As we discussed in our conversation at your office on January 5, 1998, I am writing this letter to explain why we are submitting an "after-the-fact" Hydrology Report for our property at 718 Mountain Road NW (Lot 408-A, Armijo Add'n, J14-D125).

REFERENCE: Grading and Drainage Plan for Lot numbered 408-A in Block 37, Perfecto Armijo and Brothers Addition, (recorded June 12, 1992, V 92C, F117). (City address 718 Mountain Road, NW, 'Drainage report number J14-D125).

***RE: LOT 408-A (J14-D125). GRADING AND DRAINAGE PLAN FOR SITE
DEVELOPMENT PLAN, BUILDING PERMIT, AND CERTIFICATE OF
OCCUPANCY APPROVALS. ENGINEER'S STAMP DATE IS NOT LEGIBLE.***

MARVIN R. KORTUM, P.E.  
Civil Engineering  
NM PE 6519  
1605 Speakman Drive, S.E.  
Albuquerque, New Mexico 87123  
(505) 299-0774

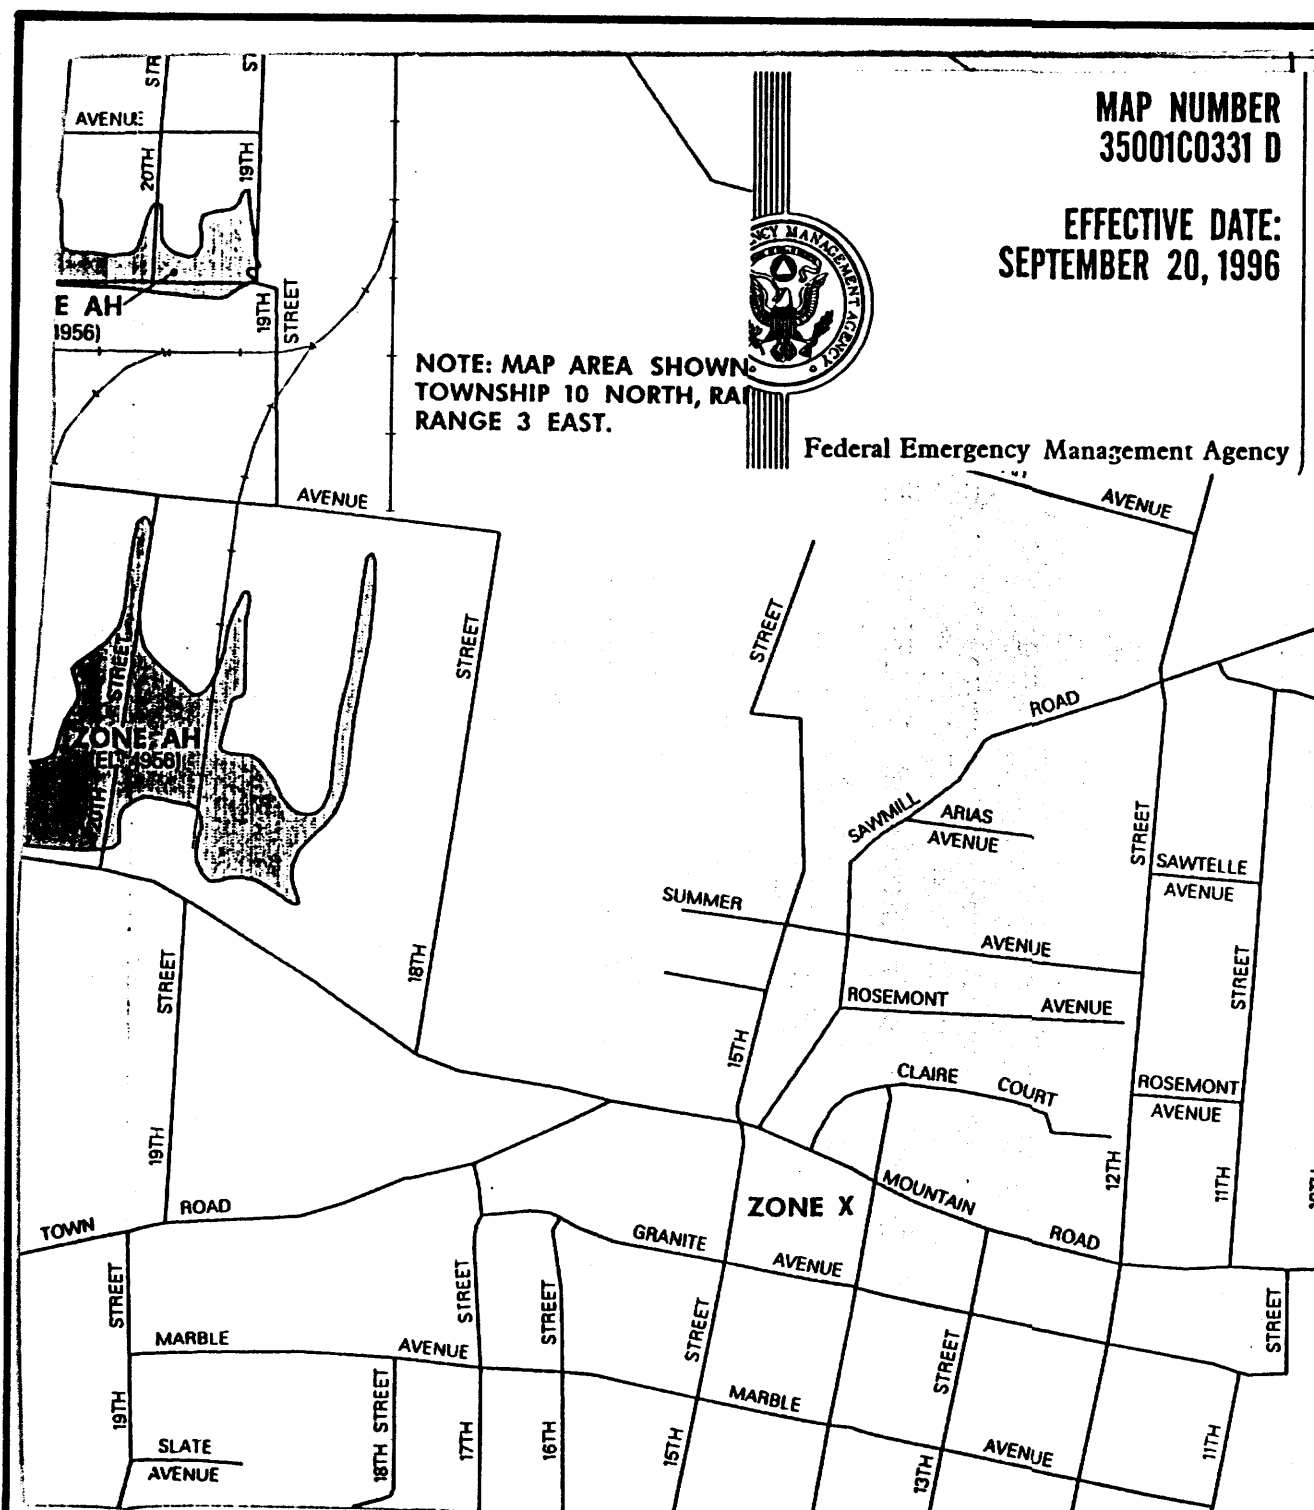
1. It appears that this site is developed with buildings 1 - 4. I am unable to tell what you want you propose to build. Why do you need a Building Permit?
2. What type of Site Development approval are you seeking?
3. Provide a legend.
4. Are you providing enough right-of-way for the City to install a sidewalk?

In answer to the other questions posed in your letter of December 24, 1997, I will speak to Mr. Kortum regarding the provision of a legend and a legible date on the Engineer's stamp. In answer to question 4, we have allowed sufficient room for a sidewalk which is scheduled to be installed this spring as part of an overall redesign and rehabilitation of Mountain Road.

Comment 3: A legend is now shown on the drawings. The current drawing bears an engineers signature dated January 14, 1998.
